Date 12 January 2022  
Our Ref 21/01881/CLP

**Town and Country Planning Act 1990 (As Amended)**  
**36 Ridgeway, Epsom, Surrey**  
**Formation of new vehicular access including crossover and drop kerb (Application for a Certificate of Lawful Development).**

| DRAWING |          | THE SITE           |      |   |          |

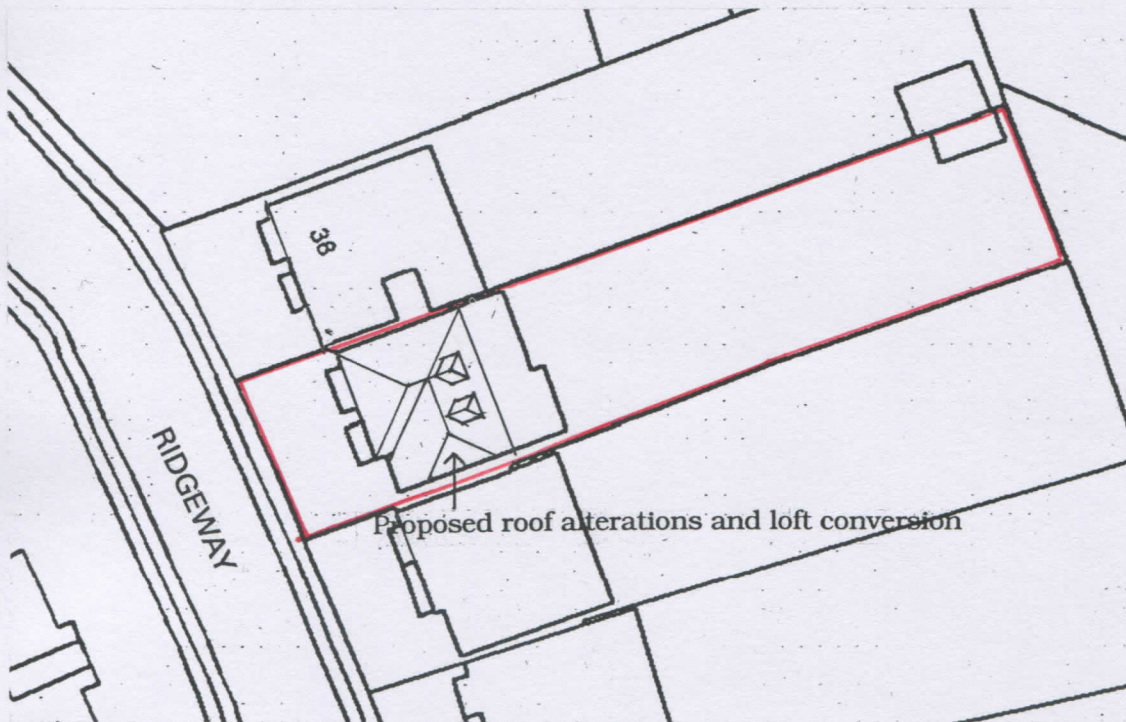
1 The submitted Block Plan is showing proposed roof extension on the submitted drawing. Please provide an accurate Block Plan (Existing and Proposed Block Plans) at scale 1:200 or 1:500 without indicating any other works been proposed, except what is on the submitted application form.
